Comments on AL/75/12 and to AL/76/12/DOC

We would like to make the following comments regarding planning application AL/75/12 and to AL/76/12/DOC.

EAST ELEVATION - 1:100

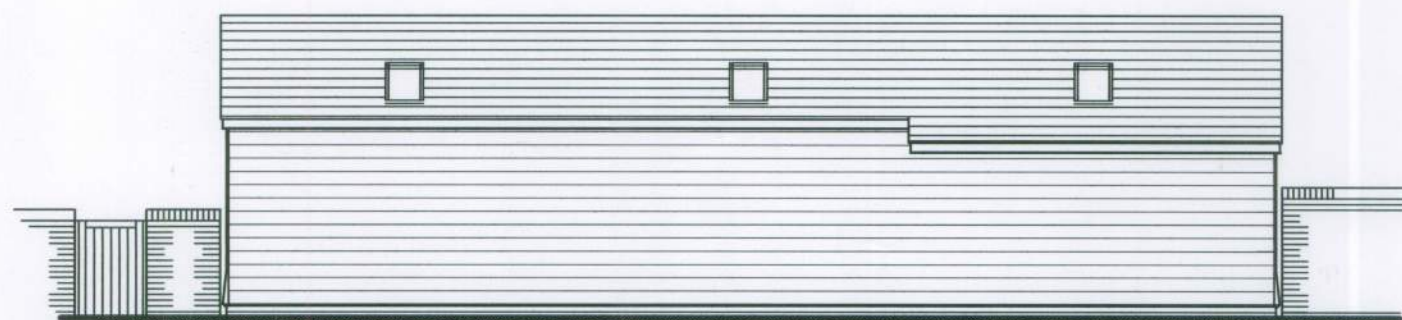
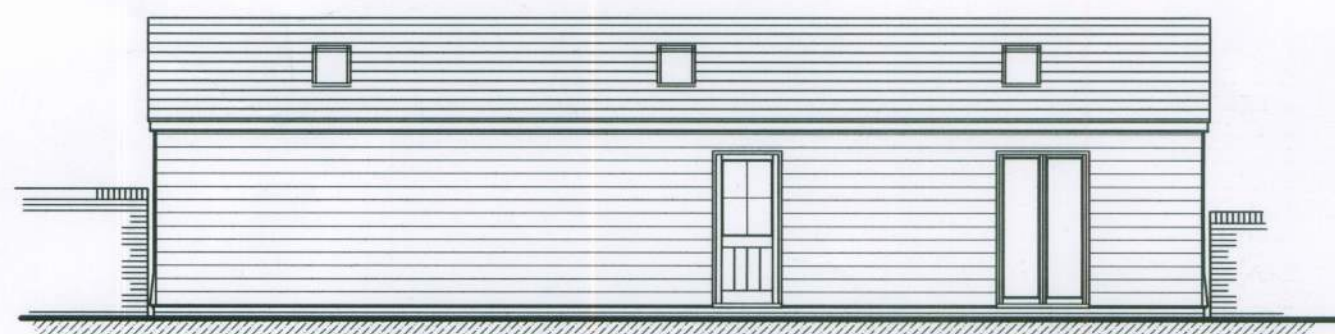
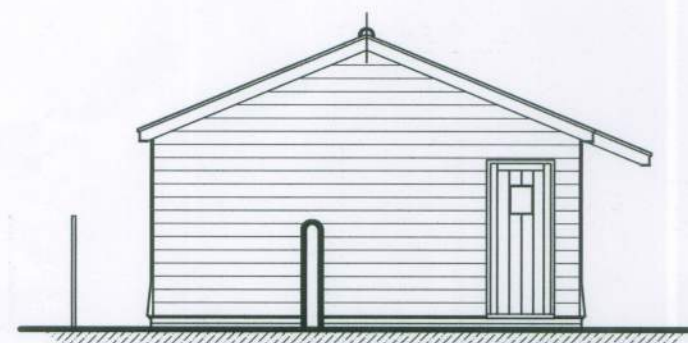
We also note that the drawings submitted are not accurate in respect of the position of openings on the flint and brick wall at the South East end of the building.

We object to the changes to fenestration. It is clear that original openings must be retained since this building is in a conservation area. This rule has been applied to our building and to other buildings on the site and so the same should be applied to East Barn. The current openings are significantly different from those on the approved plans in style and size. These rules need to be applied equally to all properties on the site.

The bin canopy on the North elevation not only significantly changes the appearance of the building but it also presents a risk to pedestrian users of the access road. There is no wall, or fence to contain any materials stored under the canopy and so there will be a tendency for it to spread into the road. This access road is becoming increasingly busy with large and fast vehicles constantly accessing the site. Any pedestrians walking along the road will be forced to walk into the road, which is going to be unsafe considering the buildings on the site are intended for holiday lets, and so will have families staying. It is vital that access to the buildings is made as safe as possible for those families. The original plans show the bins and cycle rack being stored within the enclosed

boundary on the East end of the building. This is perfectly adequate so we fail to see the need for the bin canopy.

If the canopy is approved we would expect to see the bin store enclosed using a flint and brick wall to be in keeping with the rest of the site, and a restriction placed on what materials are stored under the canopy. I.e. Only bins. However, with this, we are also very concerned that should approval be given for the bin canopy, this will merely encourage Mr May (or the current owners) to request planning for a more permanent structure or to increase the size and footprint of the house at a later stage. Furthermore, the original plans show that the area that is covered by the canopy was originally intended as a parking bay. Should the area no longer be available for use as a parking bay, where would that second vehicle be parked? There is very limited space next to the building given the nature and volume of traffic now using the site. The building seems to be predominantly used by the owner and his friends rather than being used as a holiday let, so we assume that visitors will require somewhere to park.

FLOOR PLAN 1:50

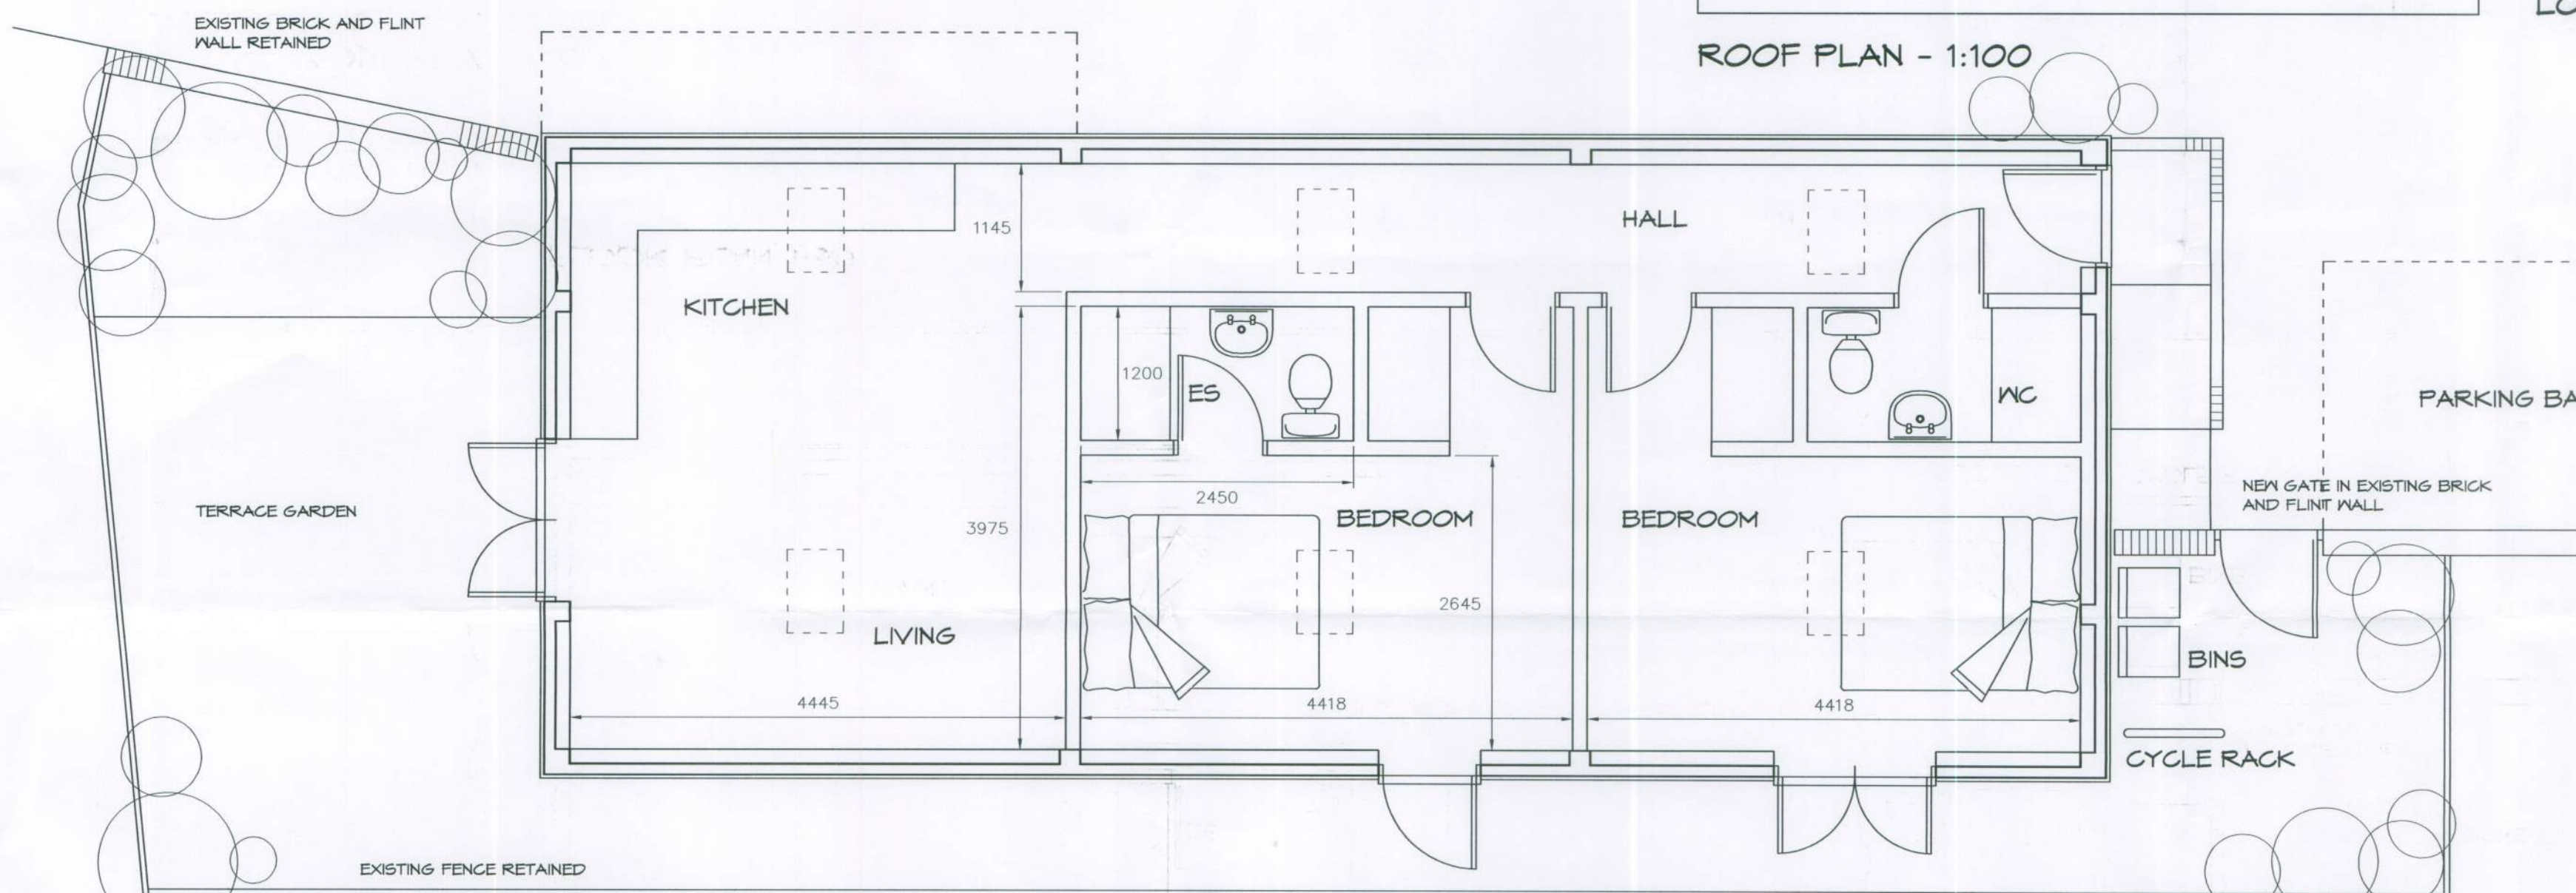
We assume that the cycle store will still be provided as shown in the original plans. This is not yet present.
